Ian Maguire
Assistant Director Planning
& Economic Growth

RE: Deadline 4 Submission in respect of the Application by AQUIND Limited for an Order granting Development Consent for the AQUIND Interconnector Project.

In line with the Examining Authority's ('the ExA') requests for deadline 4 of the examination, please find responses on behalf of Portsmouth City Council in summary form set out below:

TITLE: Application document reference 2.10 Indicative Optical Regeneration Station(s) Elevations and Floor Plans Sheet 1 of 4

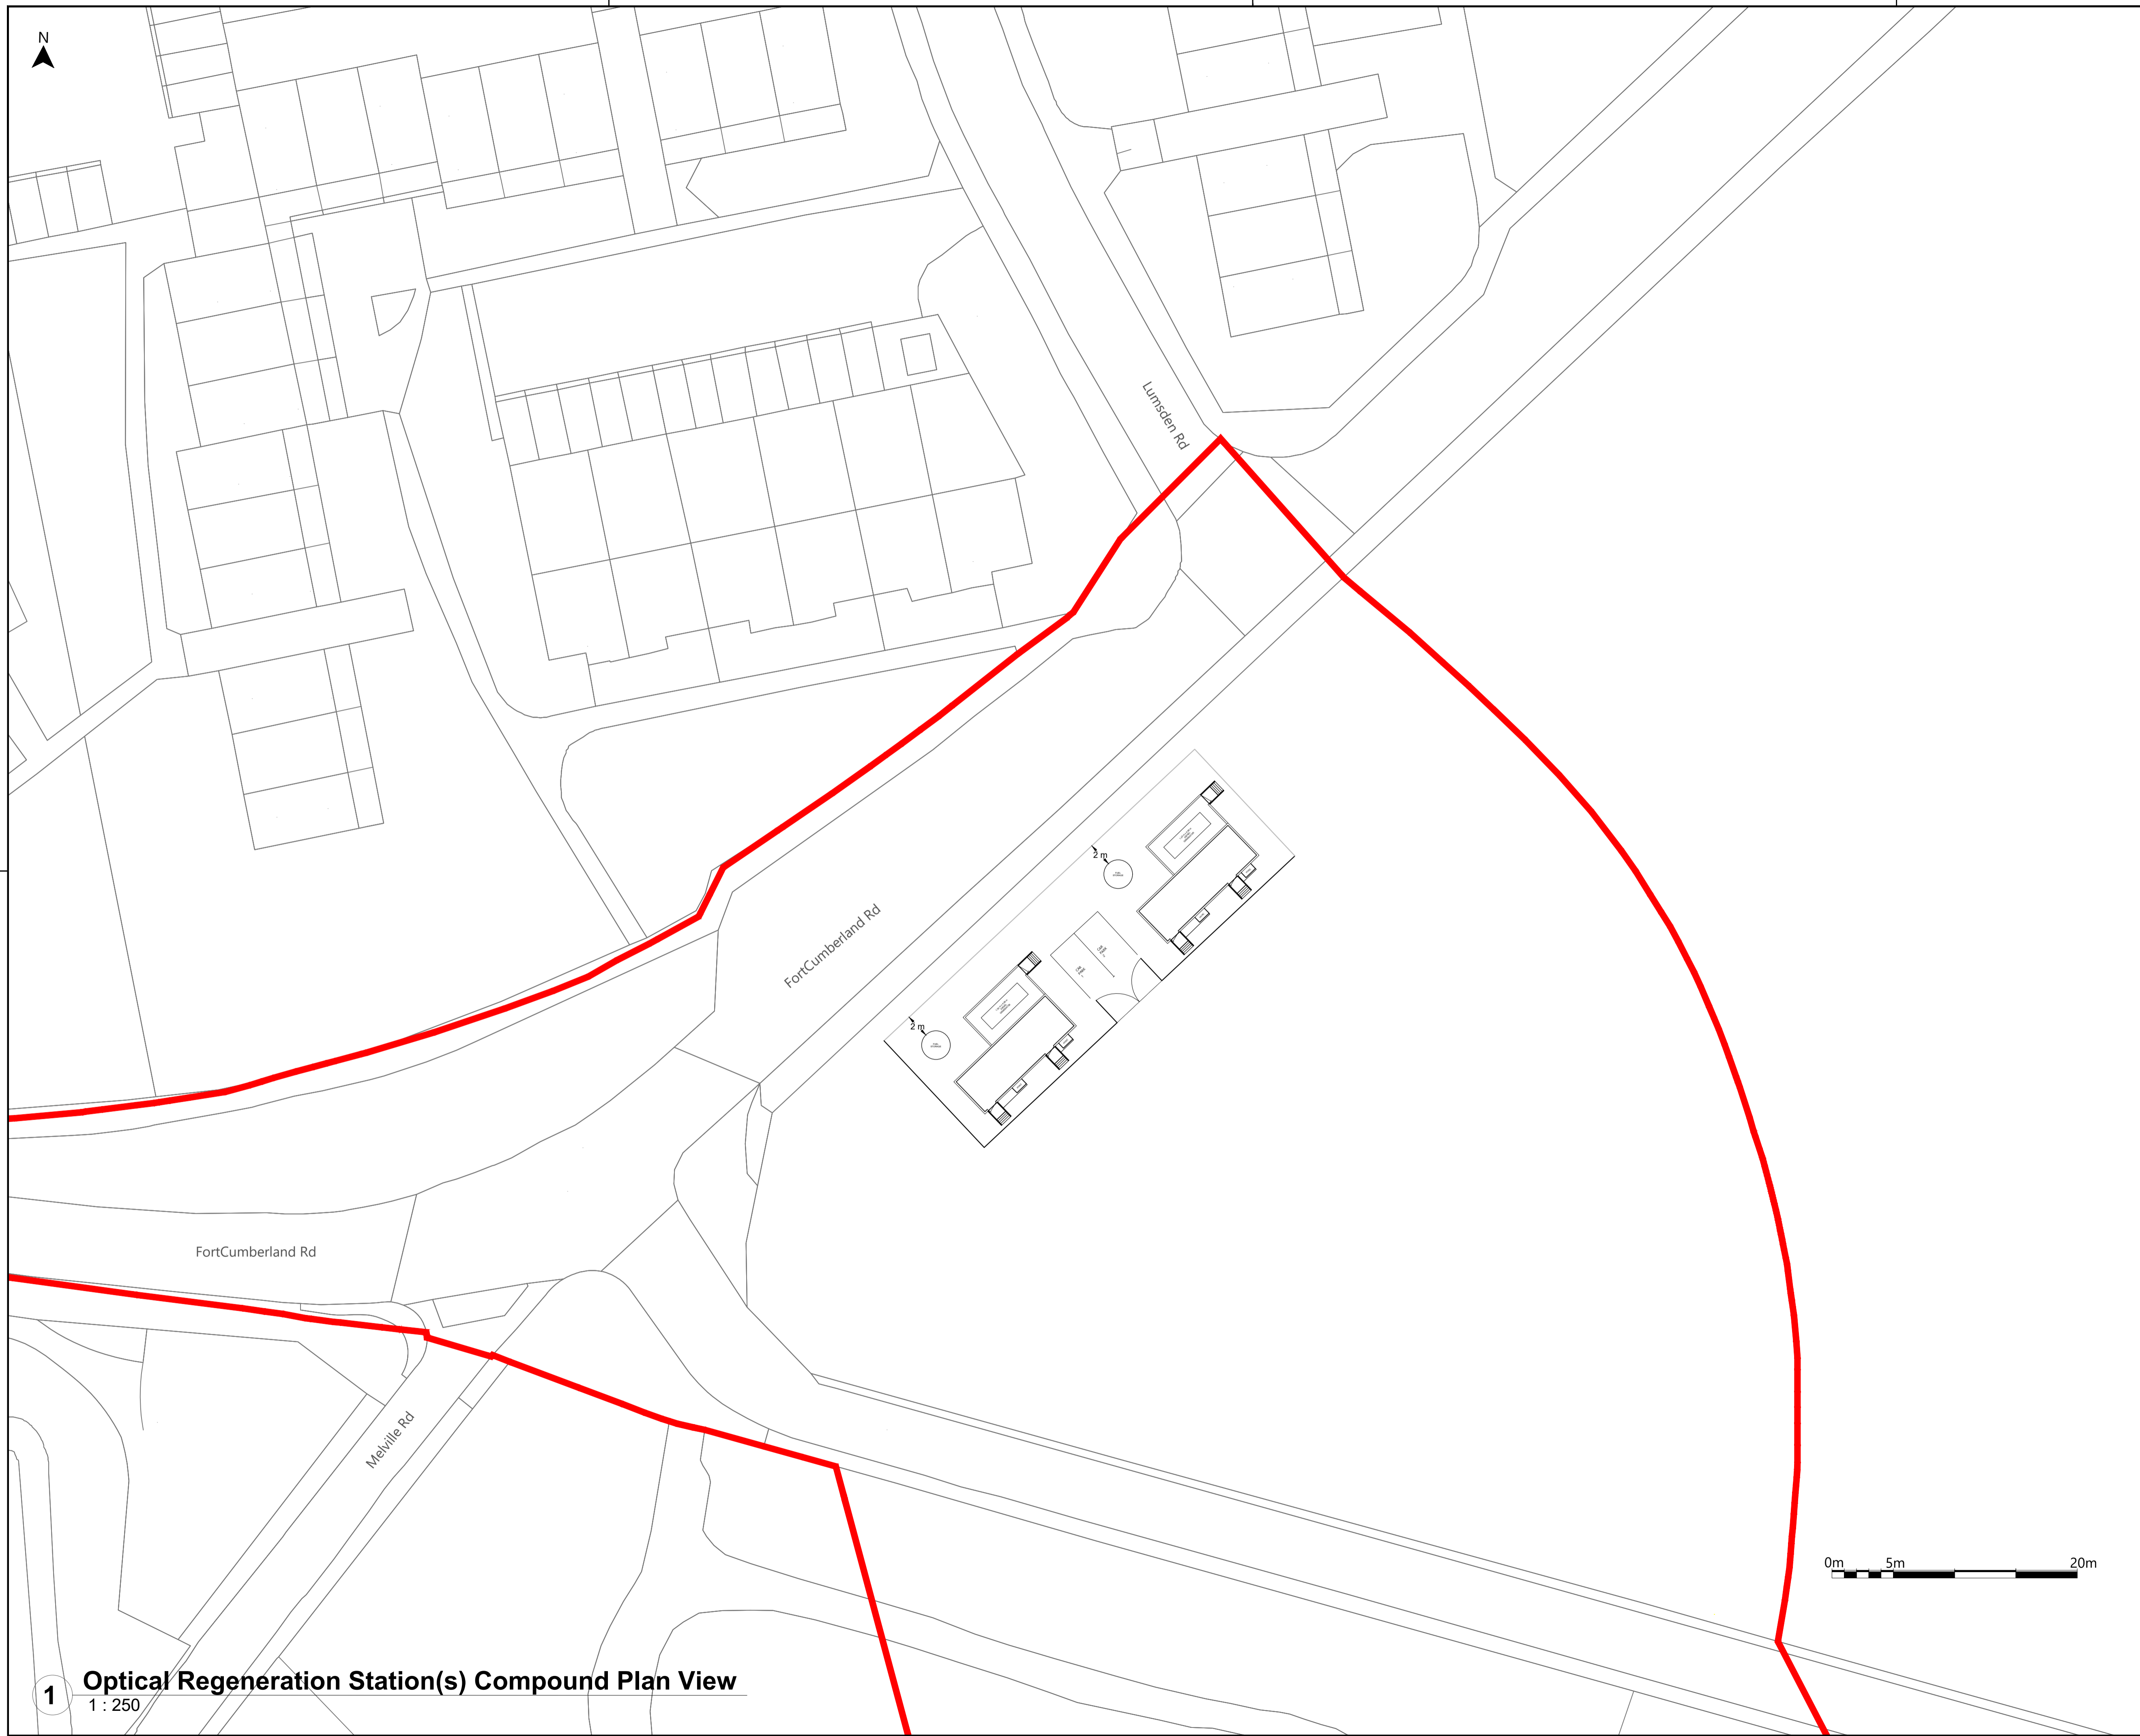
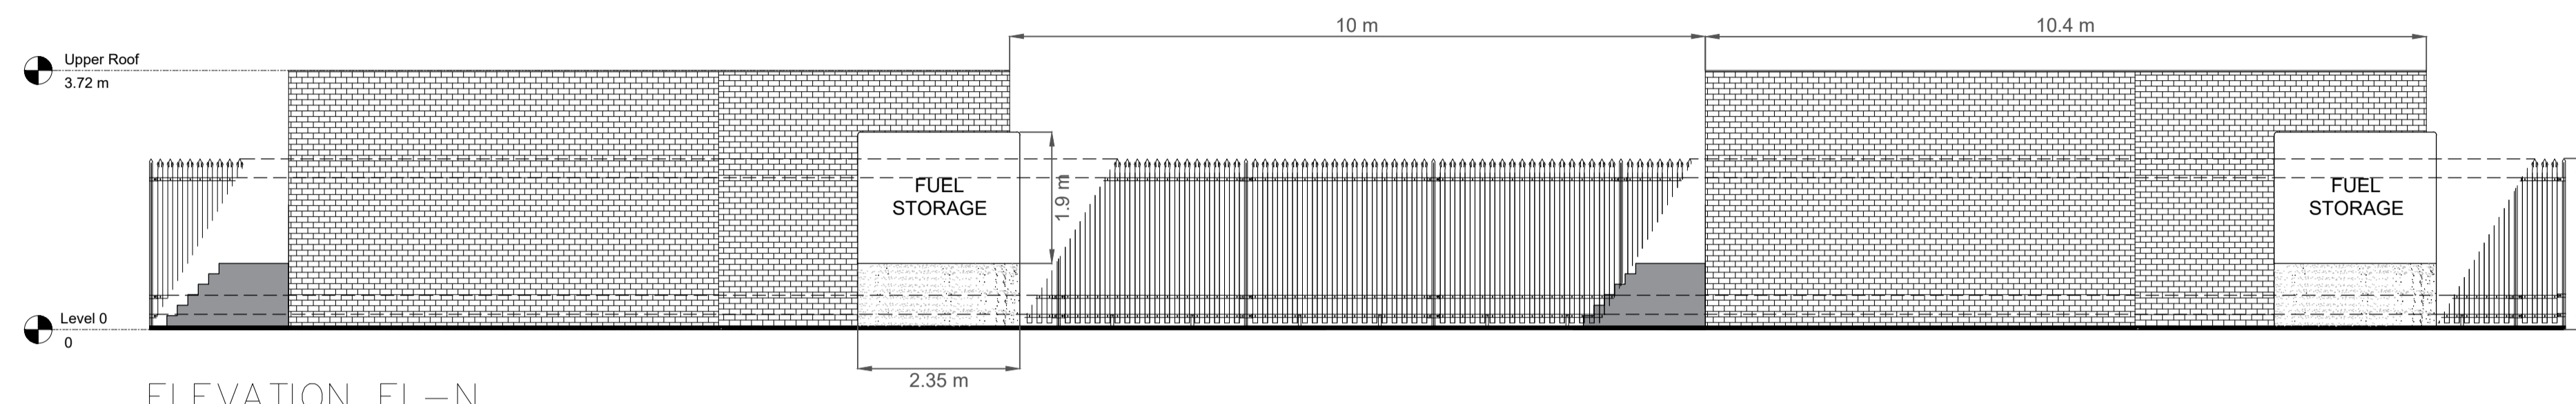
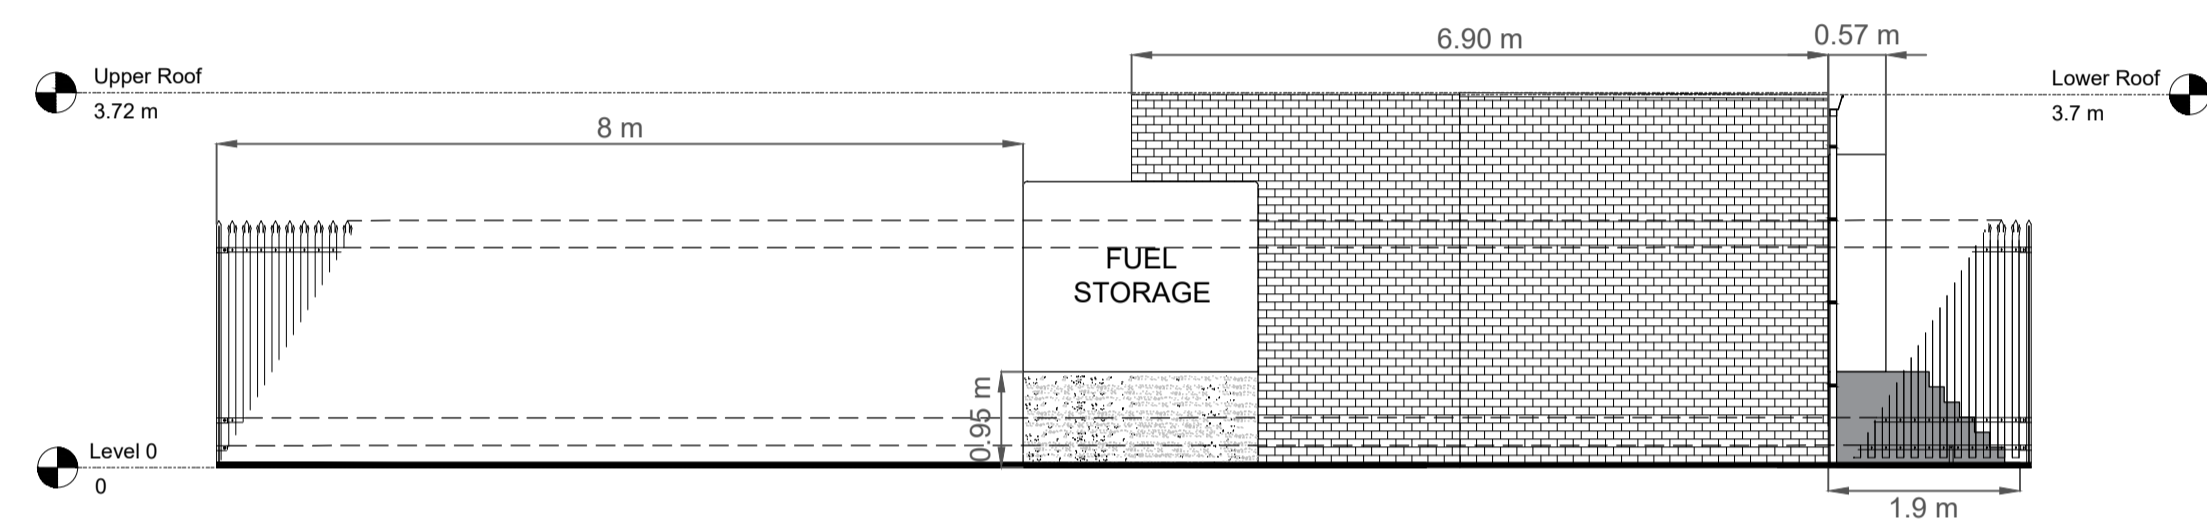
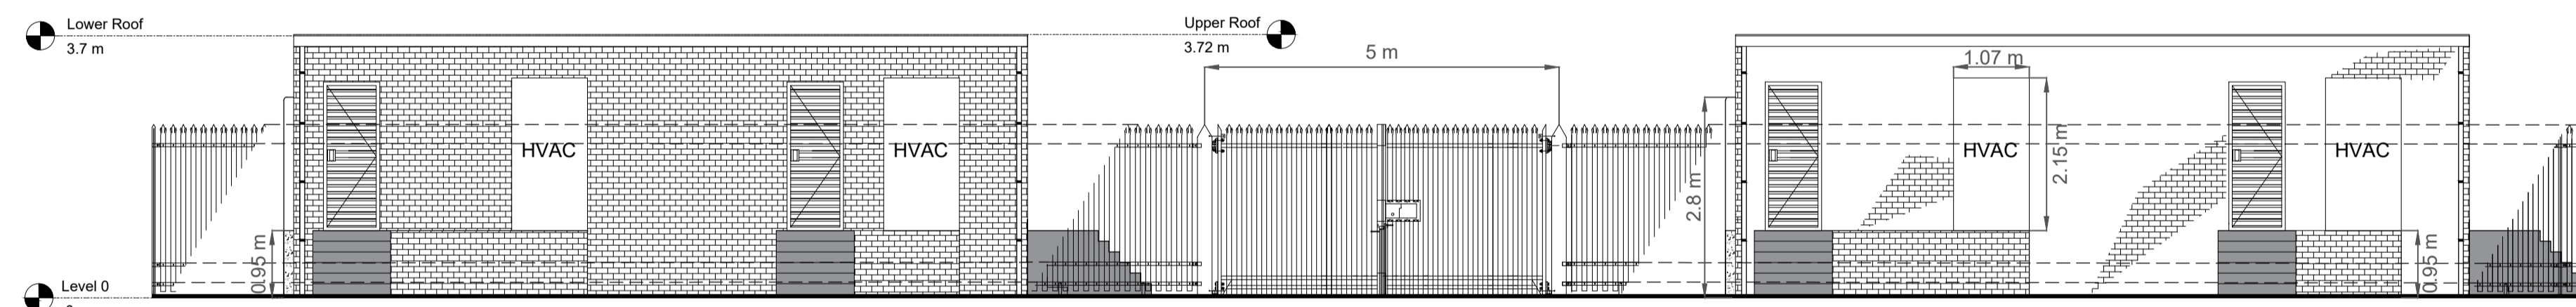
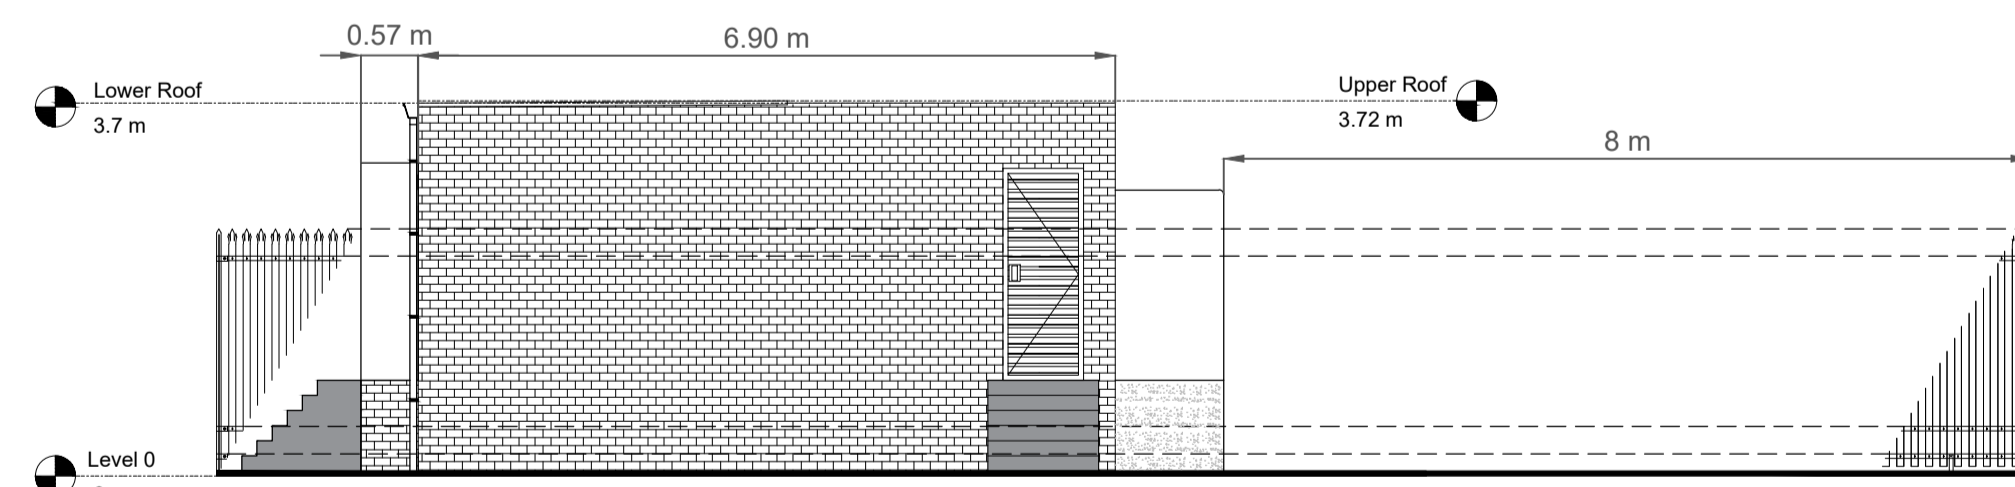
31. The Applicant, on this basis therefore have decided simply to avail themselves of this “*spare capacity*” commercial FOC because paring back that spare capacity has no visual or physical impact benefits in their view but then availing themselves of that spare capacity then leads to the need for the large ORS.

43. Furthermore the Statement in Relation to FOC (REP1-127) (doc ref 7.7.1) concedes that the full extent of the development (ORS building and telecommunications buildings) is materially influenced by the commercial FOC opportunities, which is extraneous to the central purpose of electricity transmission served by an interconnector. This ties in with the points raised above as to why this ‘spare capacity’ has arisen. Consequently, and in light of the Applicant’s response to paragraph 105, this further underscores the need in PCC’s submission for the ExA to hold an Issue Specific Hearing on Fibre Optic Cable and Associated development in order to ensure adequate examination of this important issue or at least to ensure that PCC has a fair chance to put forward its case that none of the commercial FOC related aspect of this proposed scheme can lawfully be the subject of this DCO application. Furthermore PCC. in the event of the ExA deciding to hold such an ISH would want to cross examine the Applicant’s experts put forward to explain and justify this issue to ensure the adequate testing of the Applicant’s case given their representations and responses to date as well as allowing PCC a fair chance to put its case in this regard. To be clear, whilst this may well be raised in the context of the CA hearings, the issue in PCC is a very important and material one to the ExA’s task and the SofS’s decision.

68. It should also be noted that some of the displacement from this land is unnecessary altogether. As set out in the PCC's case in respect of the proposed exercise compulsory acquisition powers, and noted above in the context of the justification for the FOC and its own infrastructure as 'associated development' within the meaning of the PC 08he ORS building clearly exceeds the requirements of the electricity interconnector i.e. the NSIP, as confirmed in the Applicant's 'Statement in Relation to FOC (Doc Ref 7.7.1)' submitted at Deadline 1) [REP1-127. This states: "*Whilst it is not possible to state with absolute certainty the extent to which the size of the ORS is dictated by the proposed commercial use, it is anticipated that approximately two thirds of the cabinets within the ORS will be available for commercial use*".

69. The Applicant therefore should acknowledge the displacement of users from Special Category Land in consequence of the ORS building. It is also PCC's case that the ORS building is not justified as associated development and its development as part of this DCO cannot be lawfully granted. Further or alternatively, if it is concluded that the principle of the ORS is justified, the ExA is asked to conclude that its size is clearly not.
